July 6, 2020

Legacy Church – Green Mountain Falls: Drainage Revision Letter

SHEET
C2.1

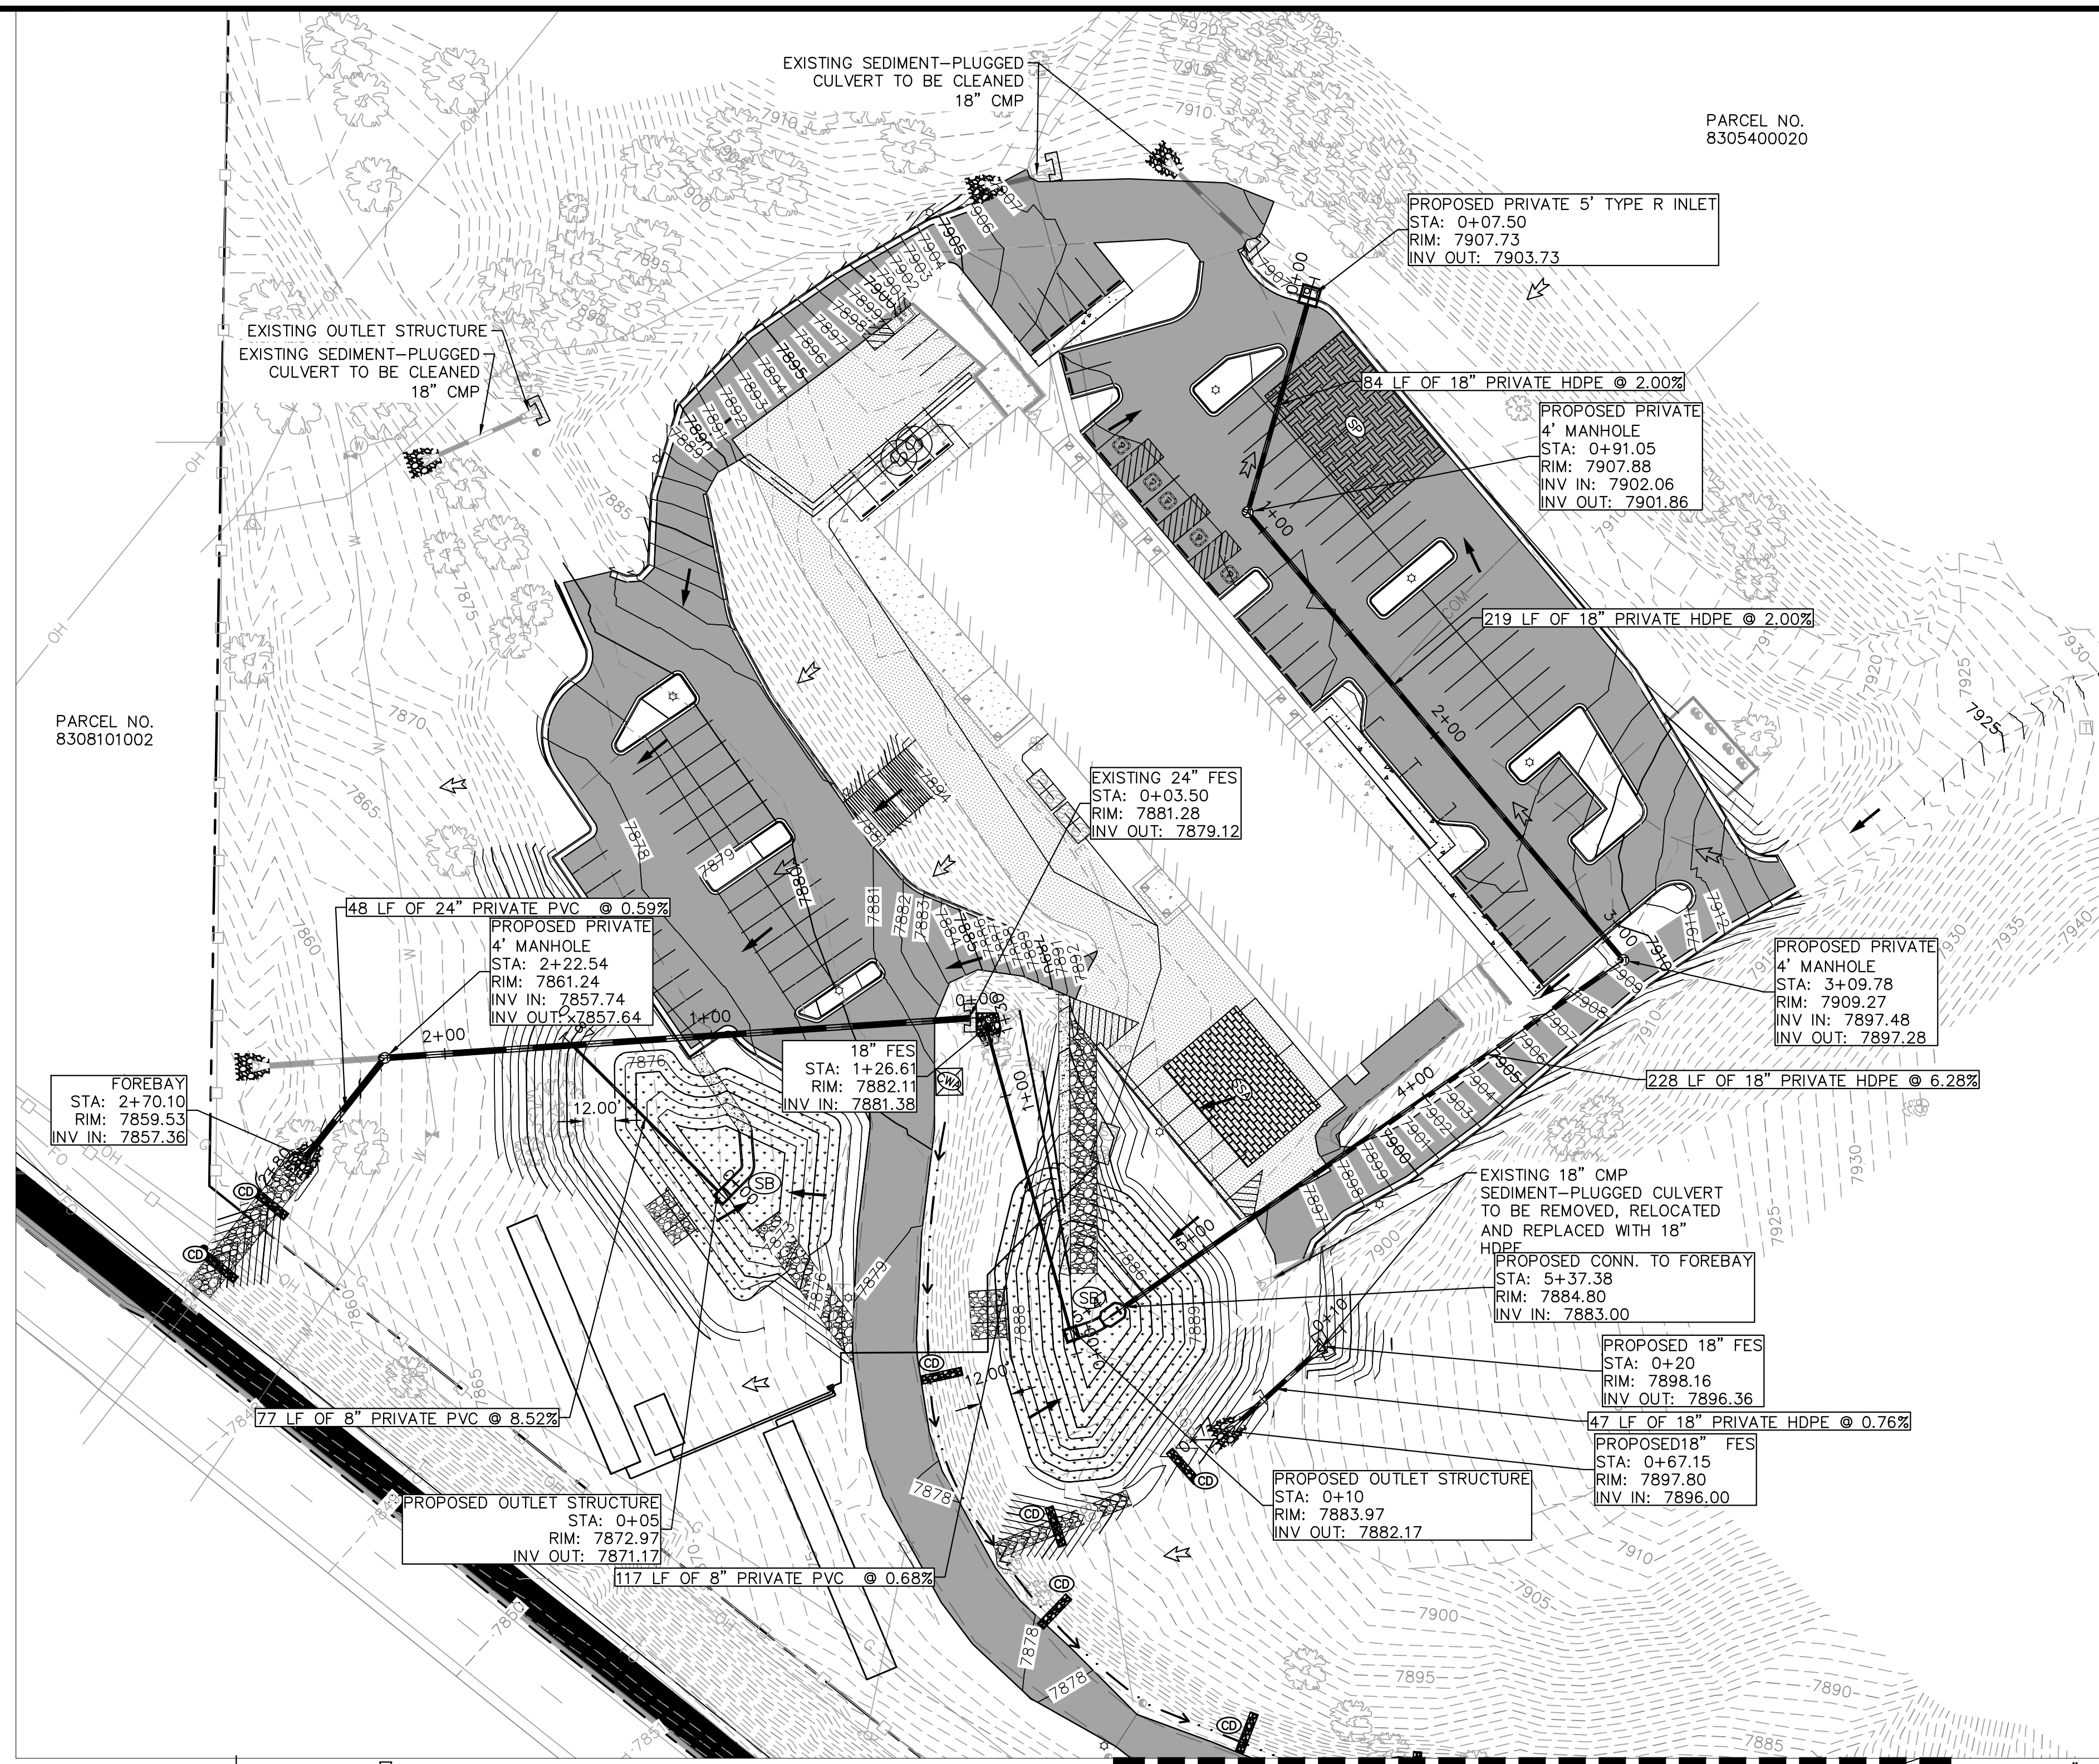
After reviewing the GEC plan it appears that impervious was added (see above). Please revise this sentence.

1. The layout of the curb/gutter in a section near the rear of the building has been revised to account for the removal of an existing ground mounted HVAC system. From this change, the net impervious area change was around 20 SF, which would not significantly impact the detention pond system.

With the expansion of a parking island in the rear of the building along the north side of the Site, the overall net impervious area was reduced.

C2.2

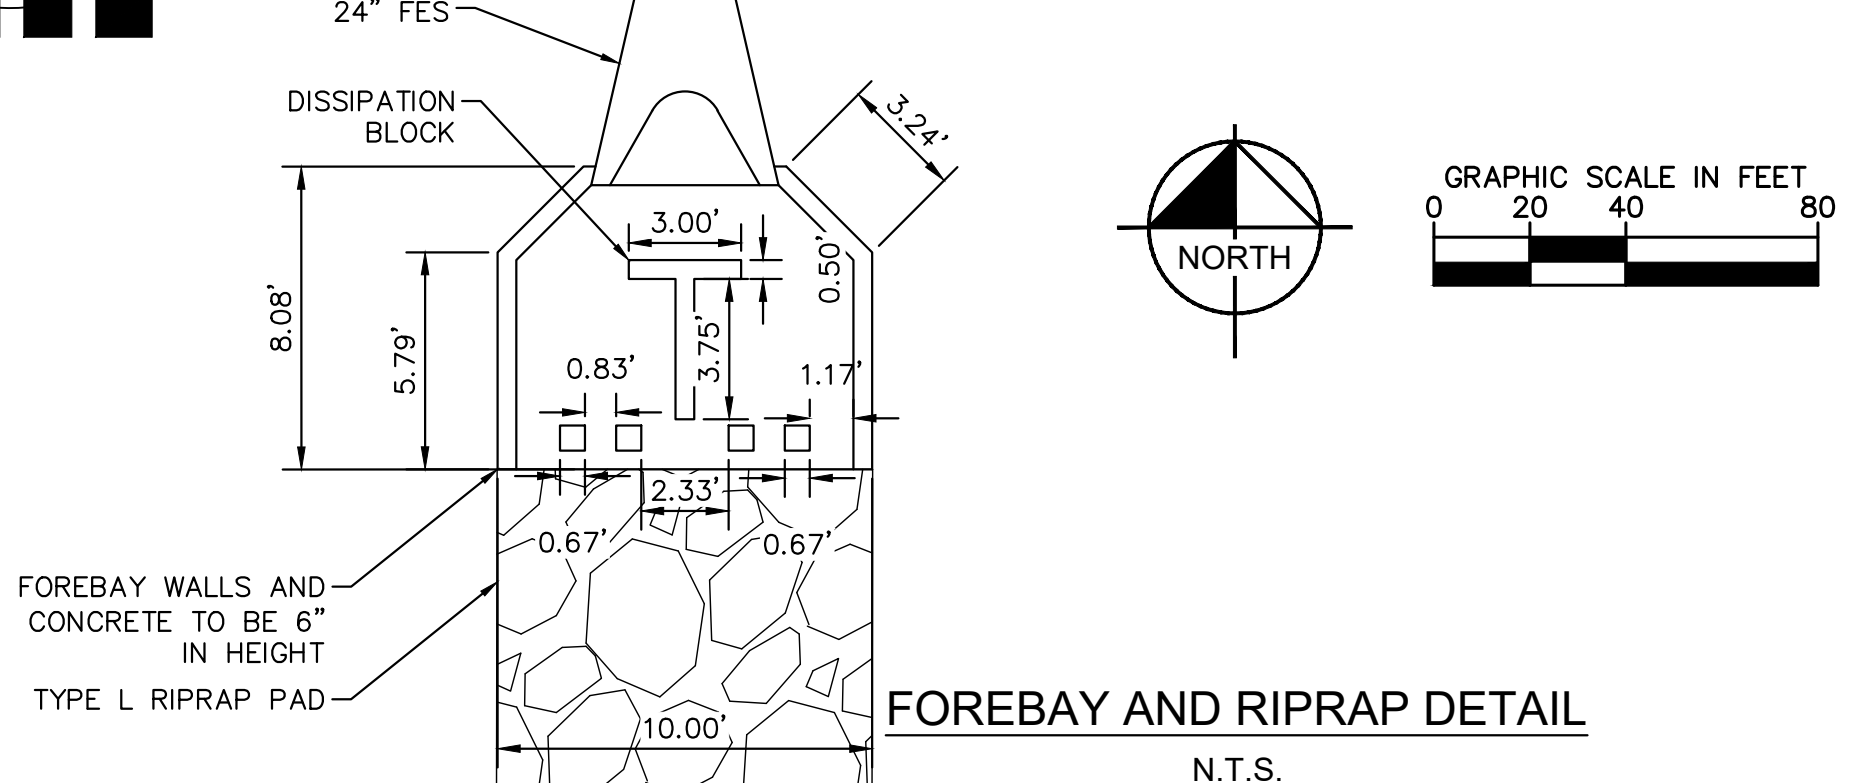
6. Pipe called out as 18" RCP on site has been updated to read 18" HDPE. This update was made for cost and constructability purposes. This pipe change does not adversely affect the proposed detention pond and storm design.

pipes

Please also state that the pipes remain adequate for the developed/designed flows.

Please provide a statement that the ponds meet all required release rates.

Please provide an overall statement that the pond and storm sewer systems are OK (Please do not copy the above statement)
